**Canal &  
River Trust**

**Your Ref** EN070007

**Friday 13 January 2023**

**RE: Hynet Carbon Dioxide Pipeline DCO Application by Liverpool Bay CCS Limited (“the Application”)**

DRAWING NUMBER
EN070007-APP-ES-17.4-Sheet 2

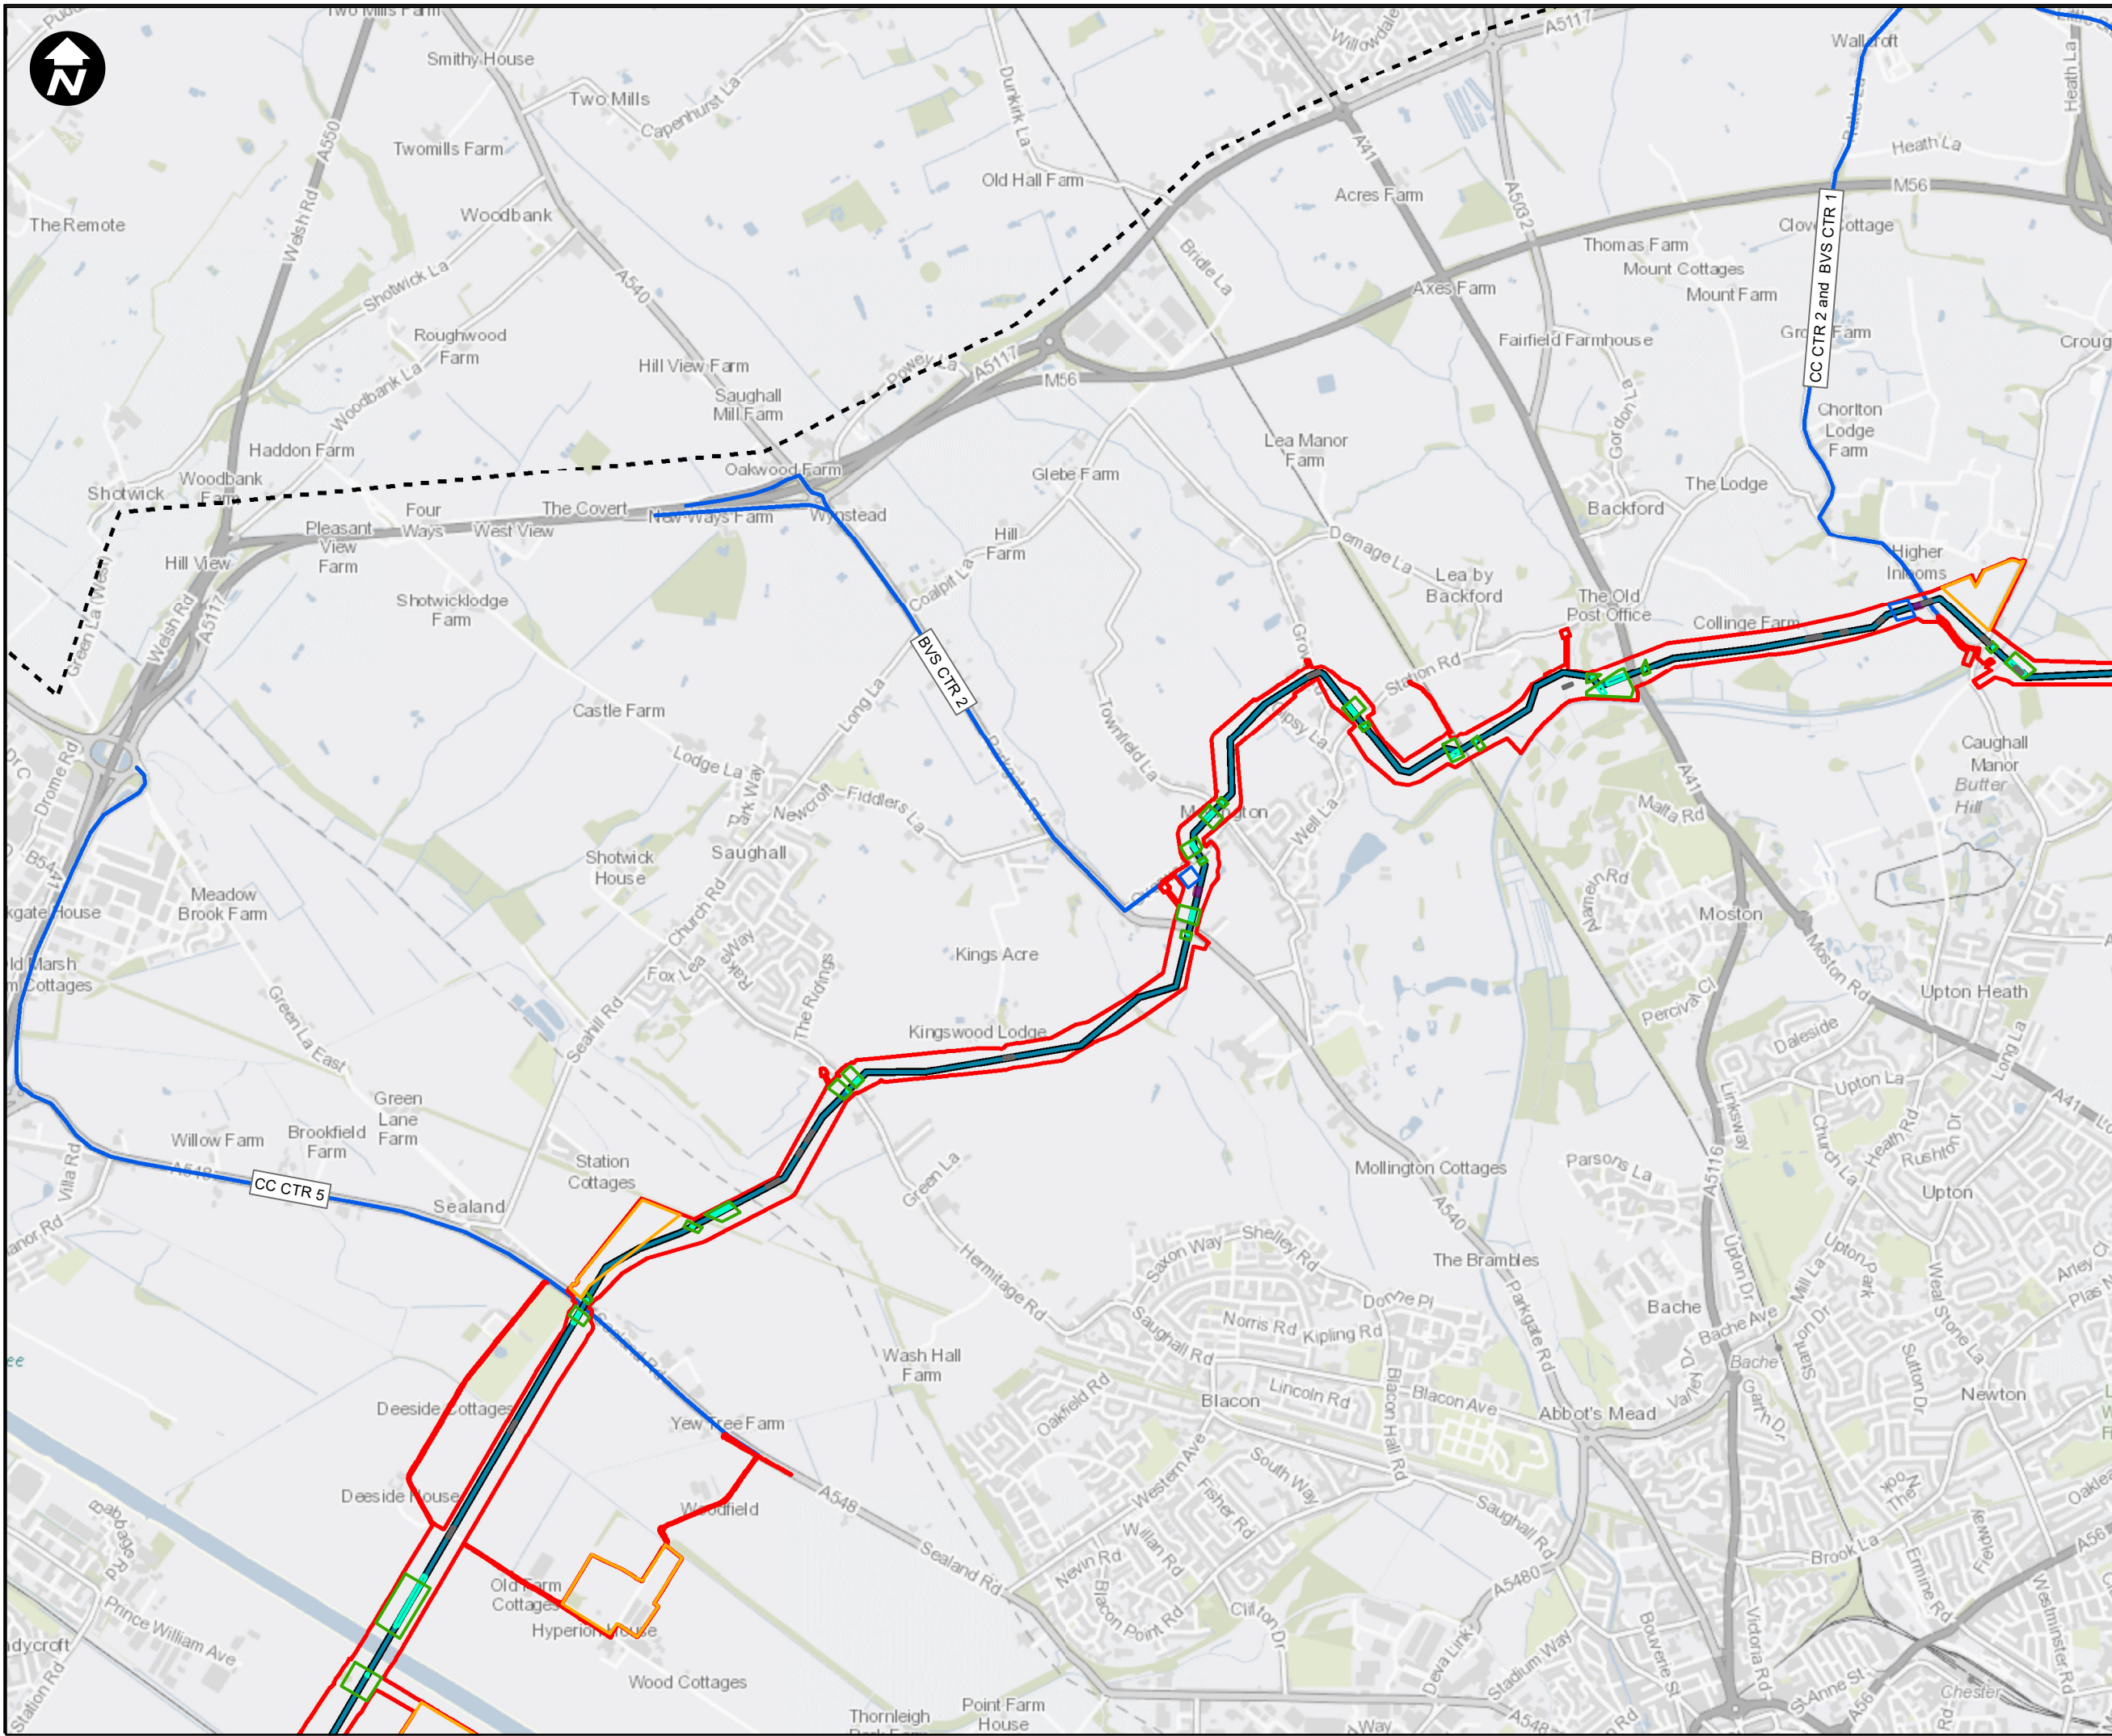
The details set out that access to the Chorlton Lane Compound via the canal crossing Pretty Bridge (Bridge 134 Caughall) over the canal has been discounted due to the bridge having a 3.5T weight limit. We welcome that Figure 17-4 Construction Traffic Route Sheet 2 of 8 shows that both construction routes CC CTR2 and CC CTR3 would be directed to avoid crossing the canal in this location to access the construction compounds.
